PROJECT #: 17-1793-B

DATE: May 18, 2023

PLAN: Lot 66 Crossings for Starlight Homes

THE FOLLOWING CHANGE(S) OR PROPOSED CHANGE(S) LISTED BELOW ARE DEVIATIONS OR CLARIFICATIONS FOR THE ABOVE REFERENCED PLANS:

ROOF

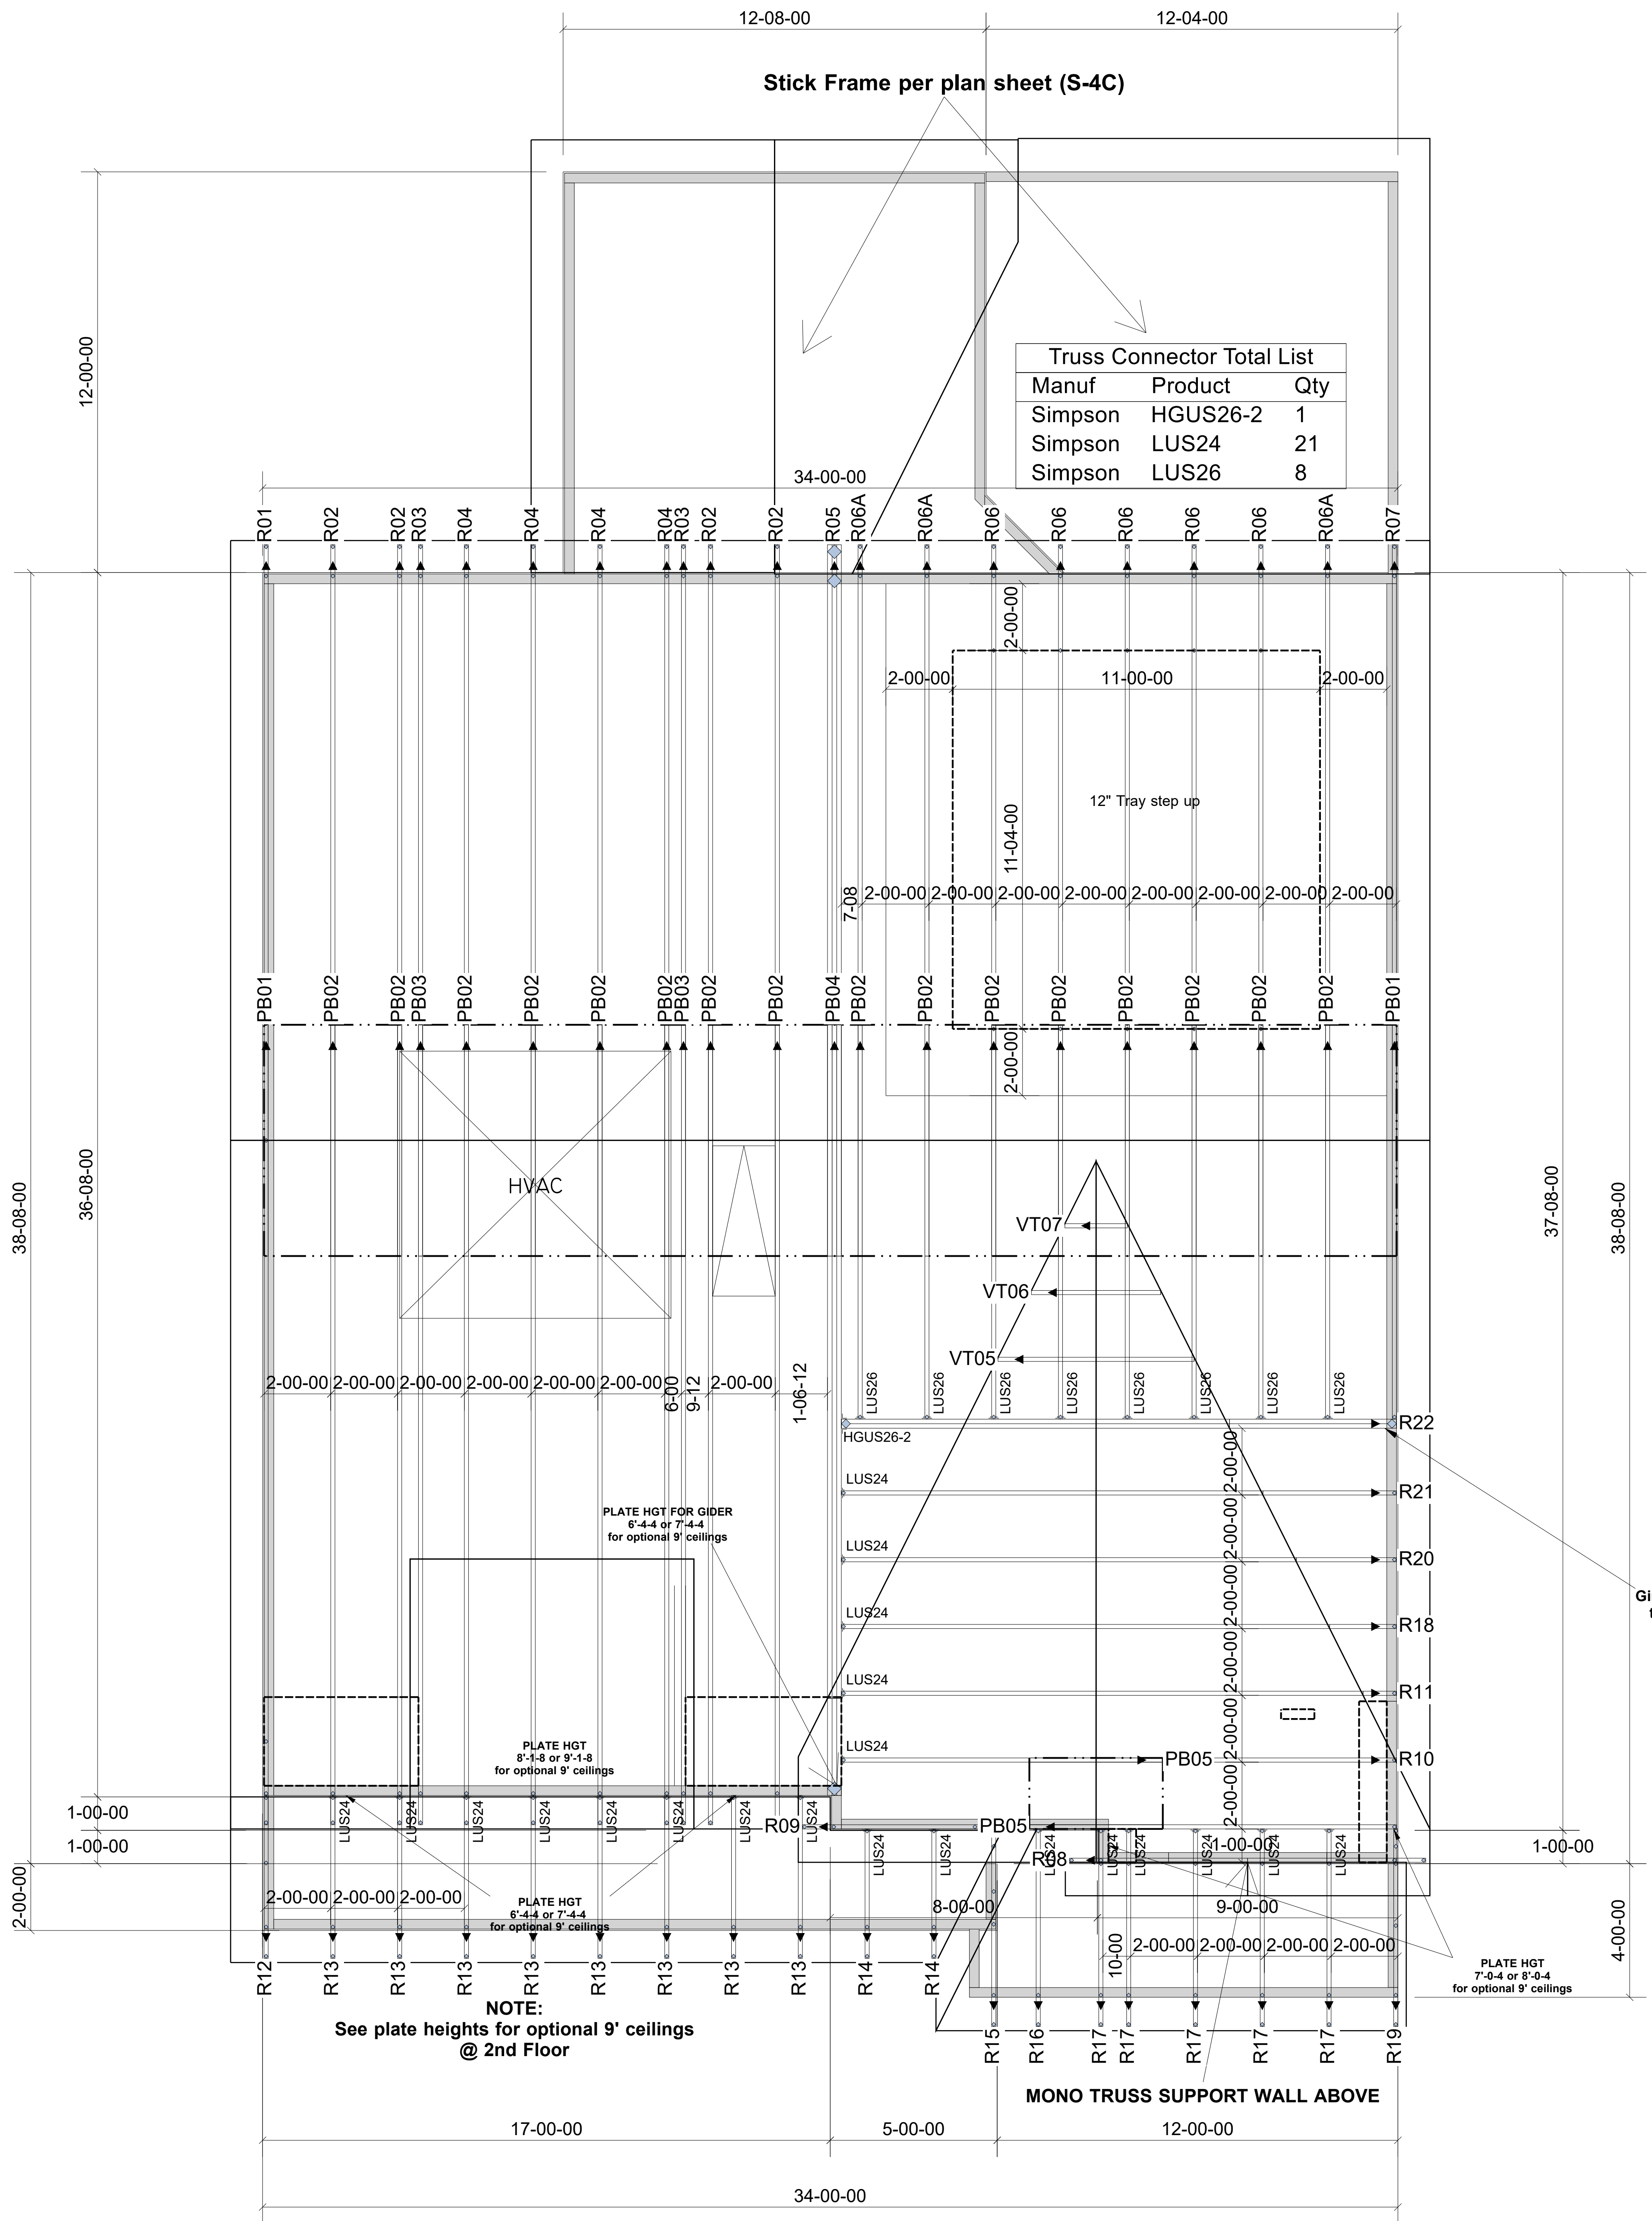
Roof Truss Elevation C: Per information from truss supplier the girder truss on elevation C spanning left to right had to be shifted towards the back to align with the front bath wall. It attaches to a girder truss with a hanger on the left side and is supported on the right exterior wall with (3) studs.

Please be advised the truss modification is structurally adequate and therefore repairs are not required.
